**Subject:** Notice of Exhibition for Barangaroo South 1A Subdivision (Third Phase) (SSD 8997)

From the information submitted, the following information has **not** been provided in the Plan of Subdivision as per the SEARs:

HICKSON ROAD

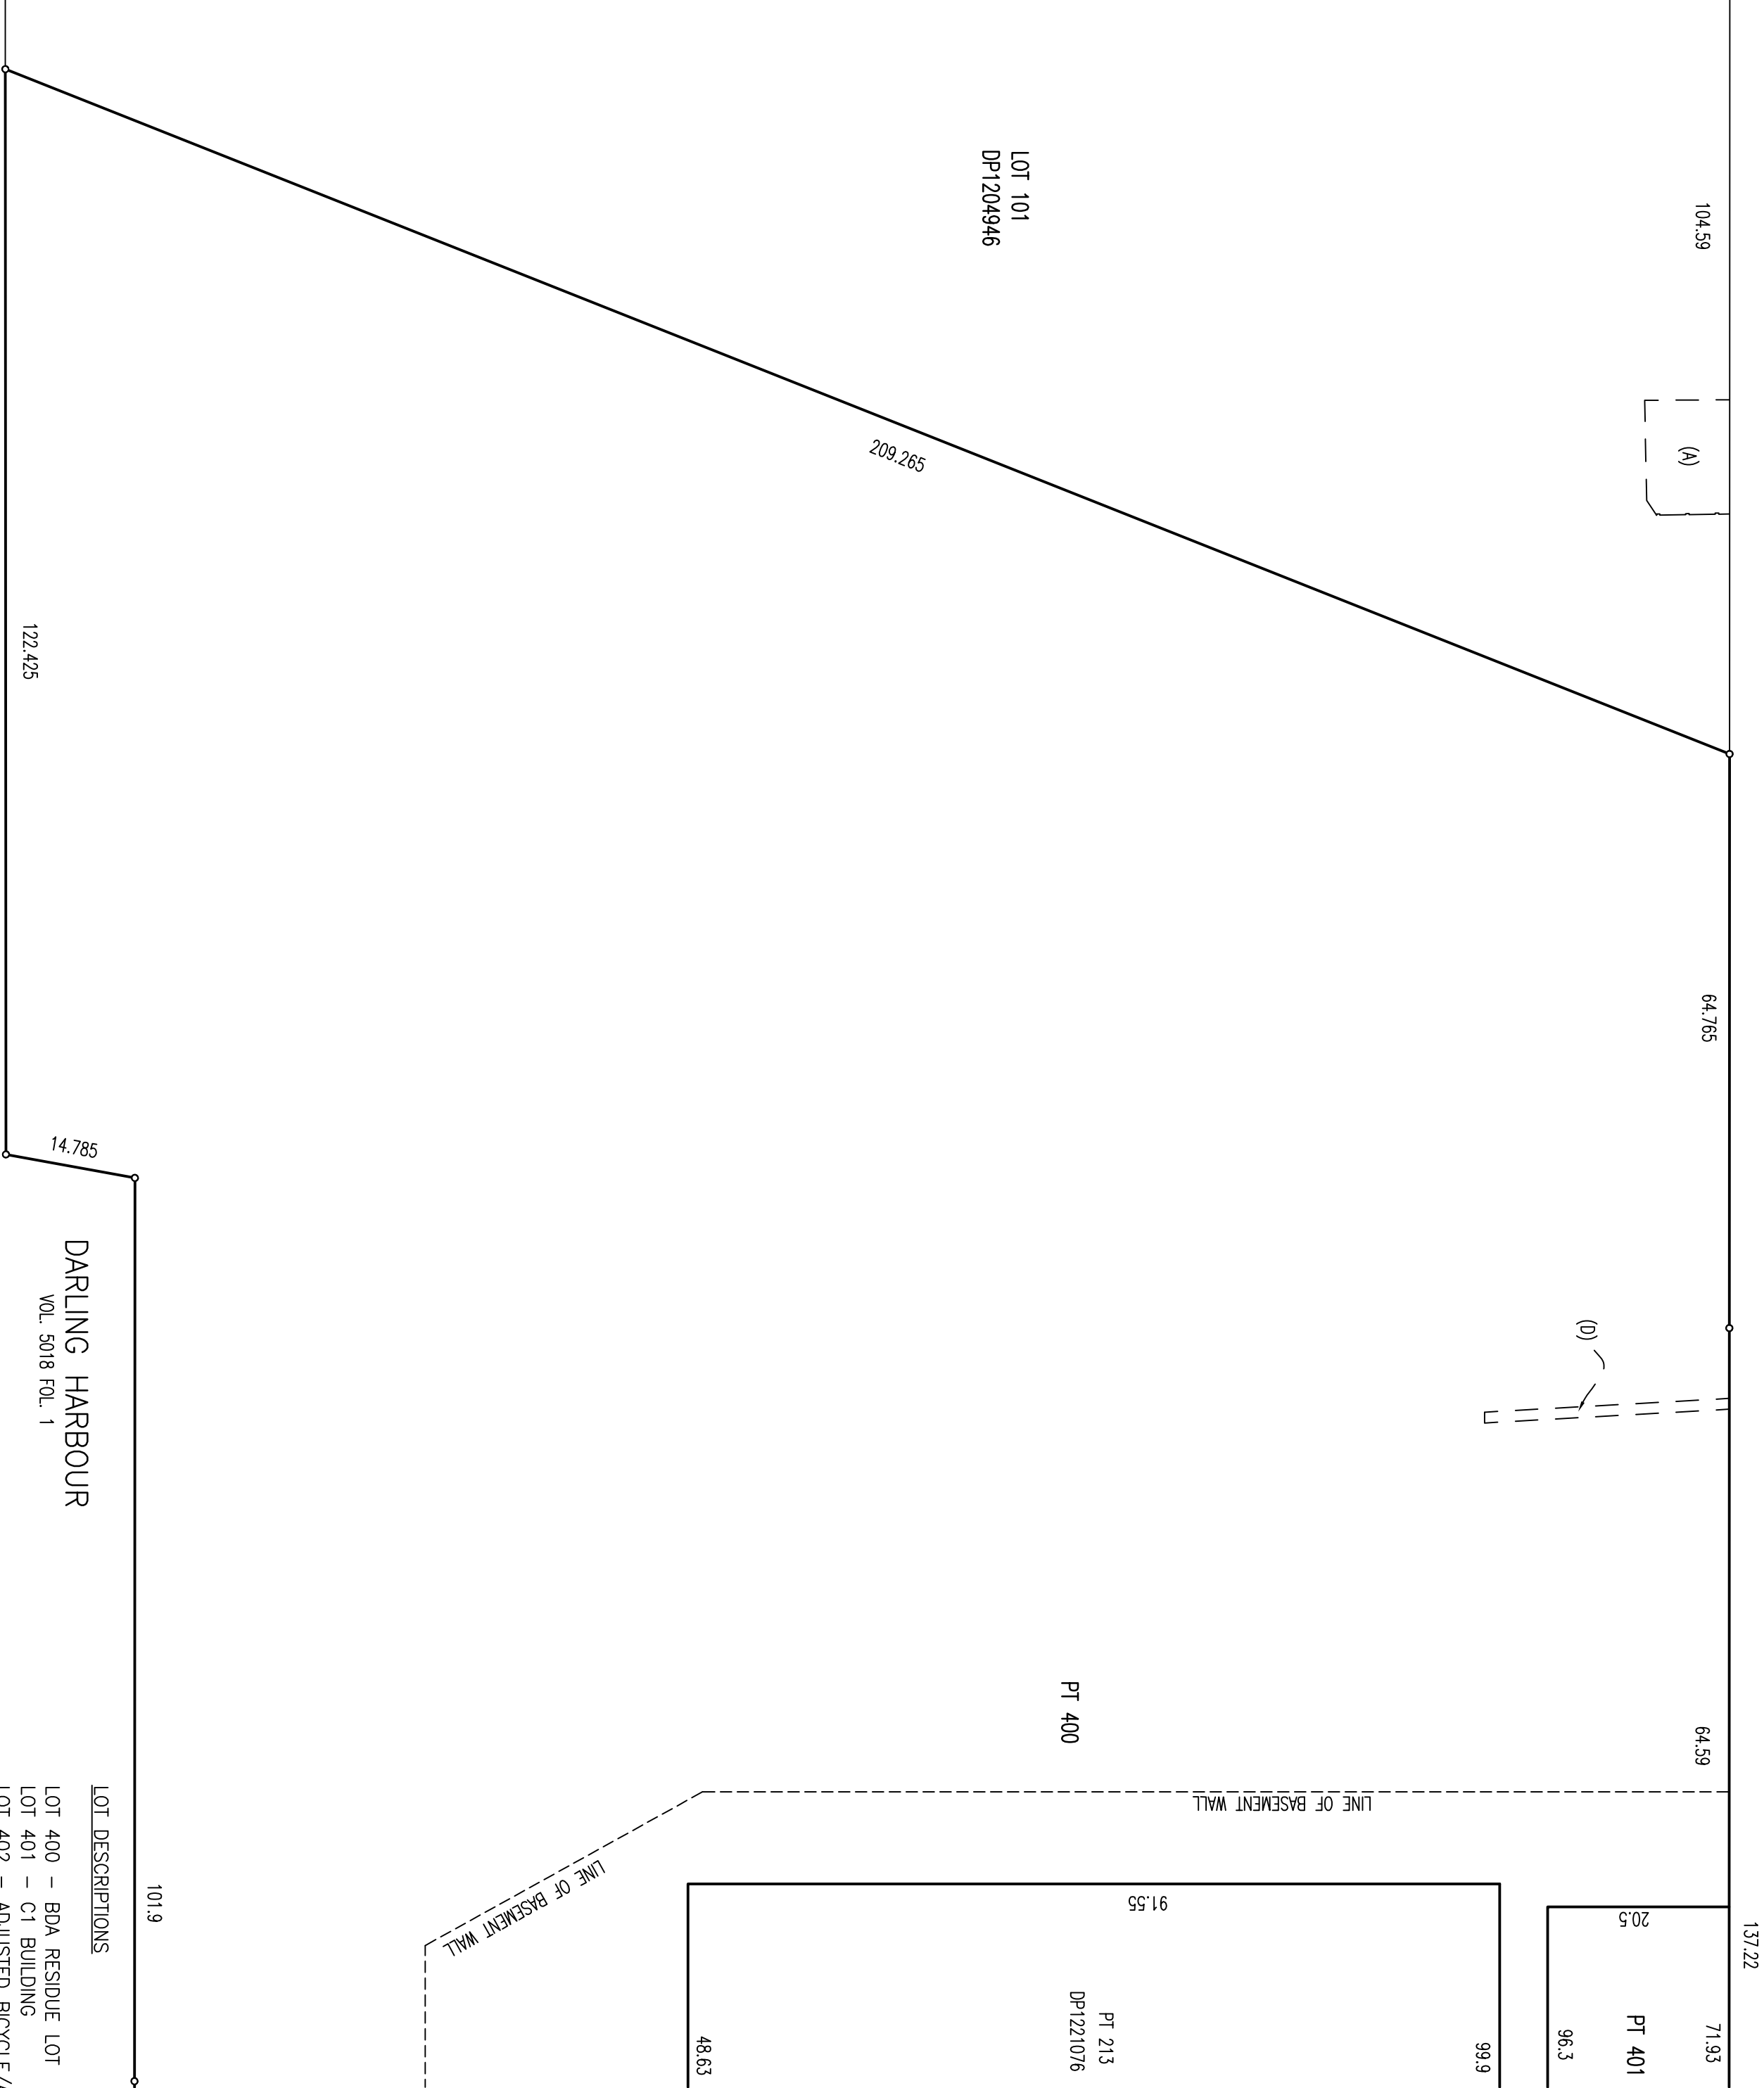
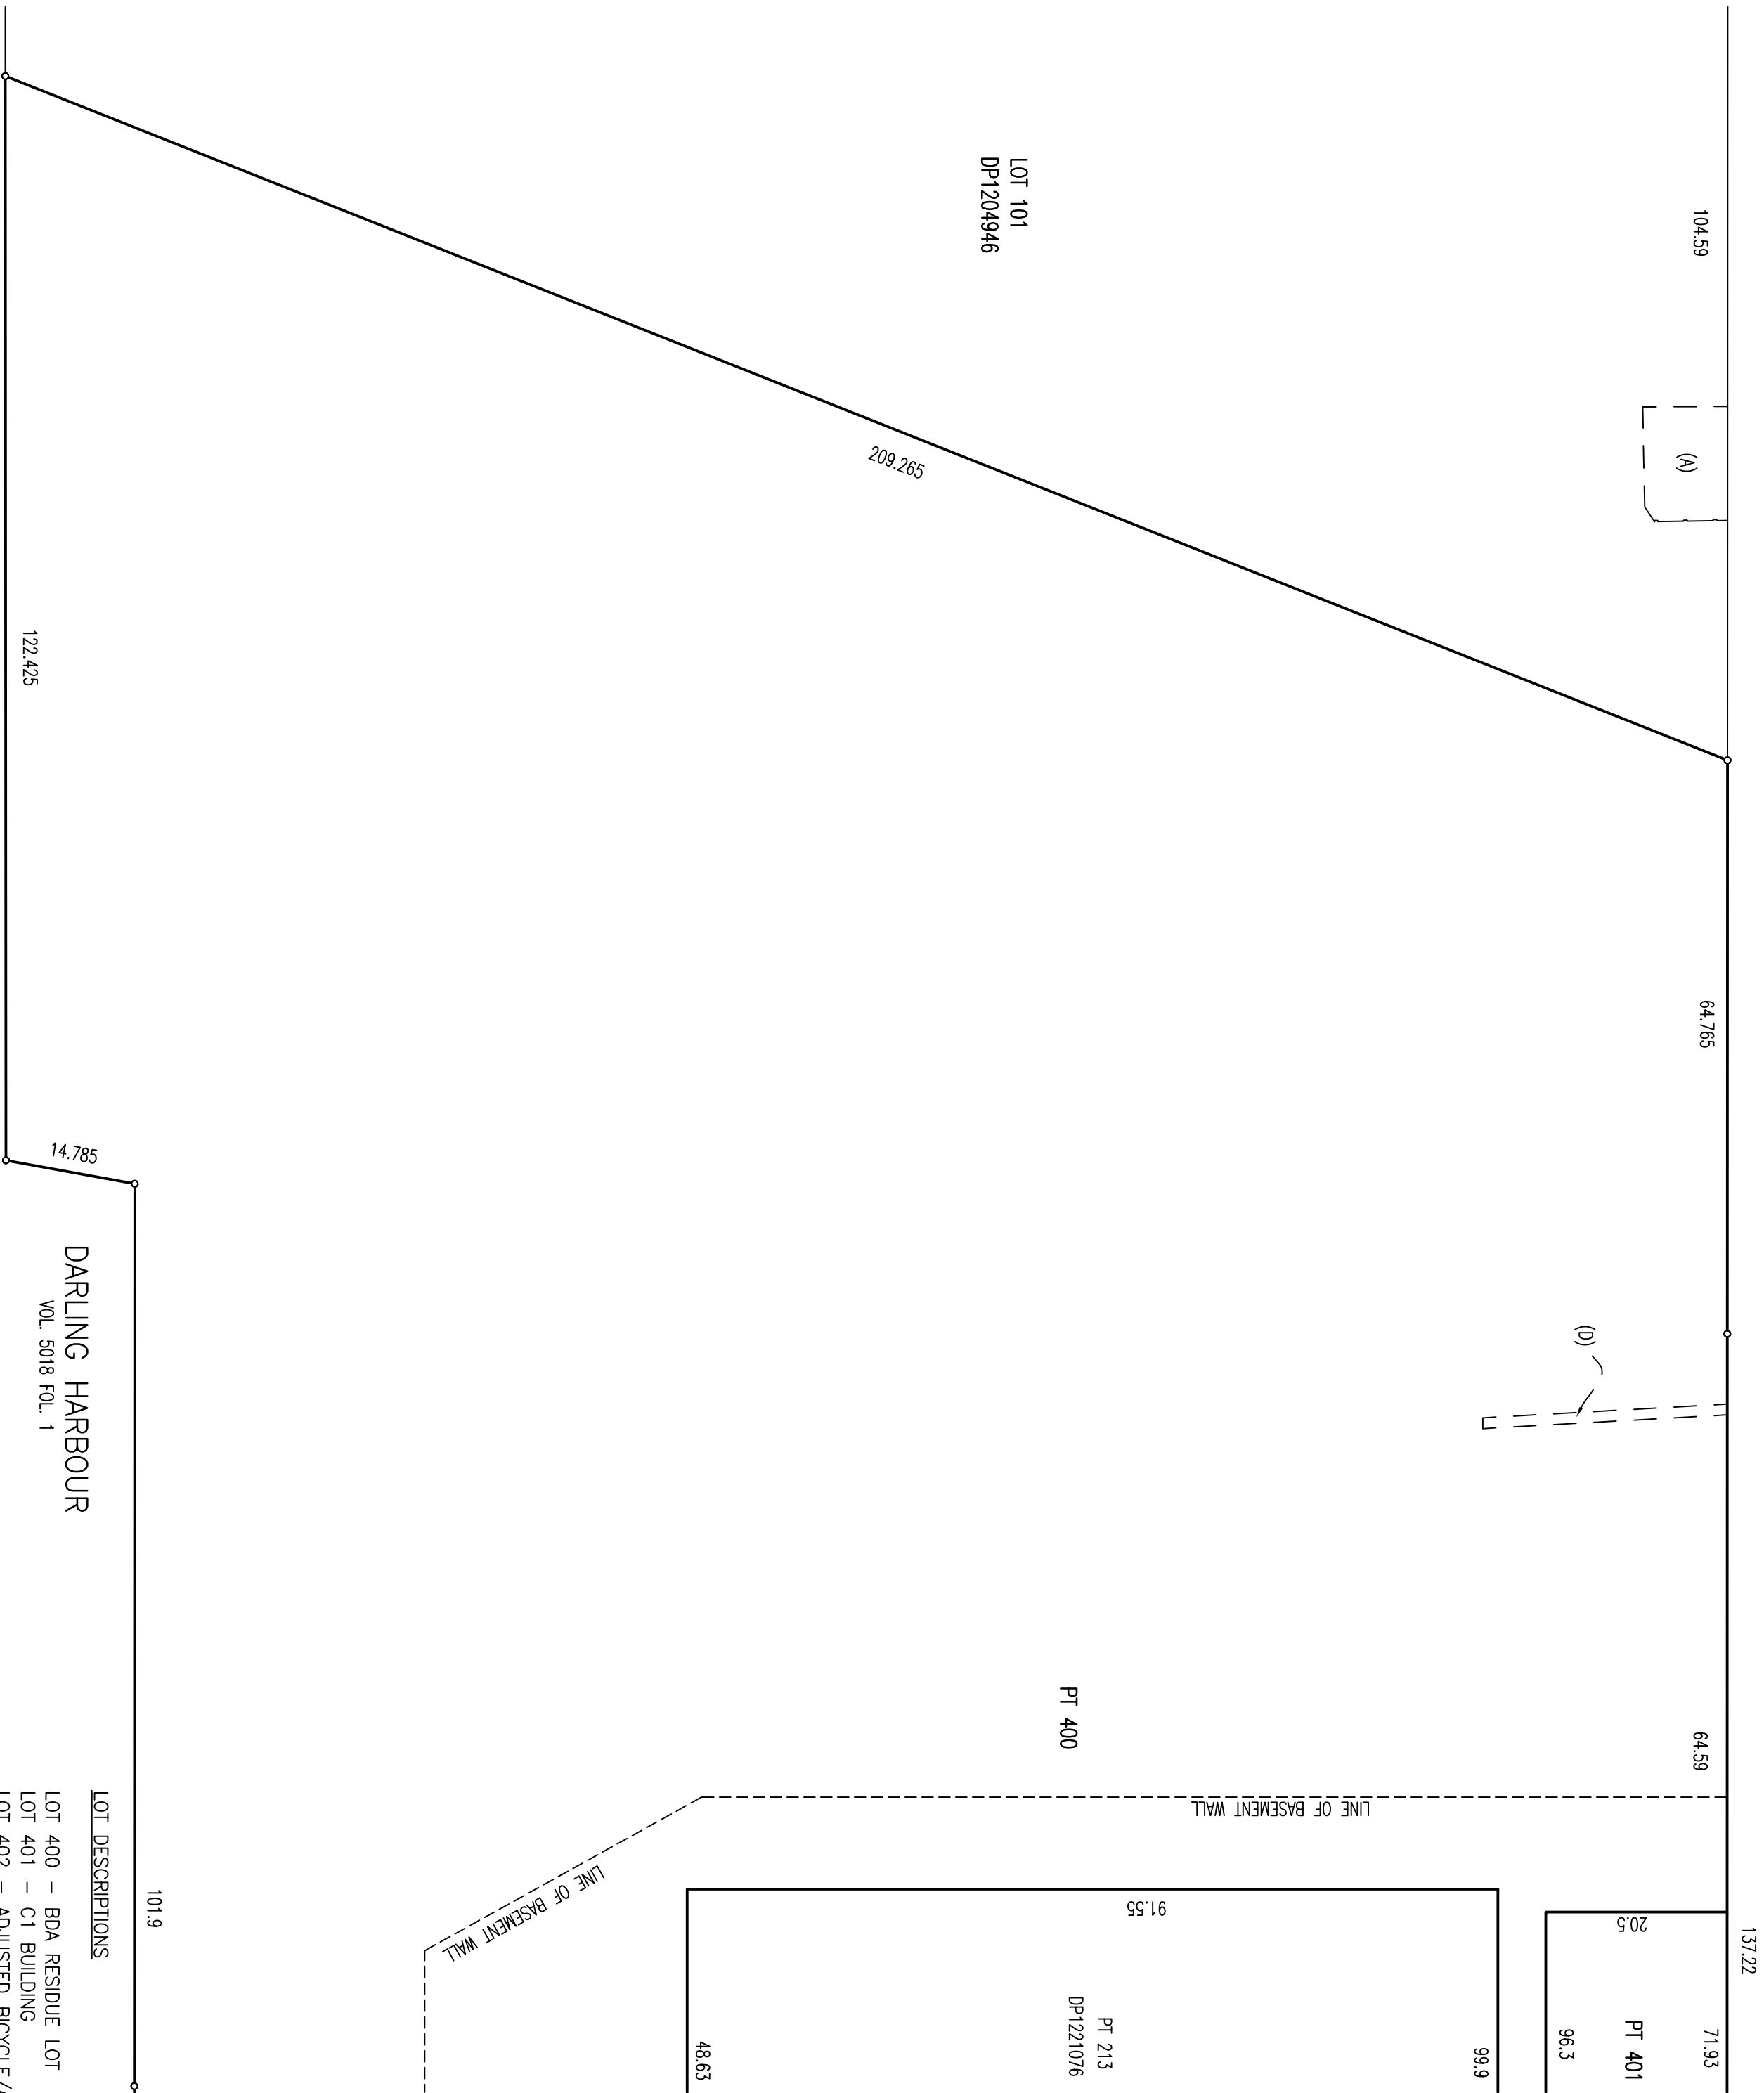
- **no details of any covenants, easements, notations, rights of way or the like proposed to ensure appropriate access is provided to each service provider to enable the on-going maintenance of their assets and to enable public access to the public domain areas have been provided and**
- **the information does not include a draft Section 88b instrument and a building management statement where relevant.**

The plans do not show any easements or covenants, therefore the Department should ensure:

- Compliance with SEARs.
- Compliance with previous approval for the development of the site. For example, full compliance must be given to the conditions of the SSD development consents contained within the Instrument of Approval, and as subsequently amended, in relation to the development of the subject site where applicable to this subdivision.

- Easements under Section 196 of Conveyancing Act: Documentary reciprocal easements for services, drainage, support and shelter, and emergency egress, affecting the whole of each lot if so desired, must be created over the lots in the subdivision, pursuant to Section 88B of the *Conveyancing Act 1919* and to Council's satisfaction.

- Additional easements: Any other documentary easements or any other encumbrances and indemnities required for joint or reciprocal use of part or all of the proposed lots as a consequence of the subdivision must be created over appropriate lots in the subdivision, pursuant to Section 88B of the *Conveyancing Act 1919* and to Council's satisfaction.
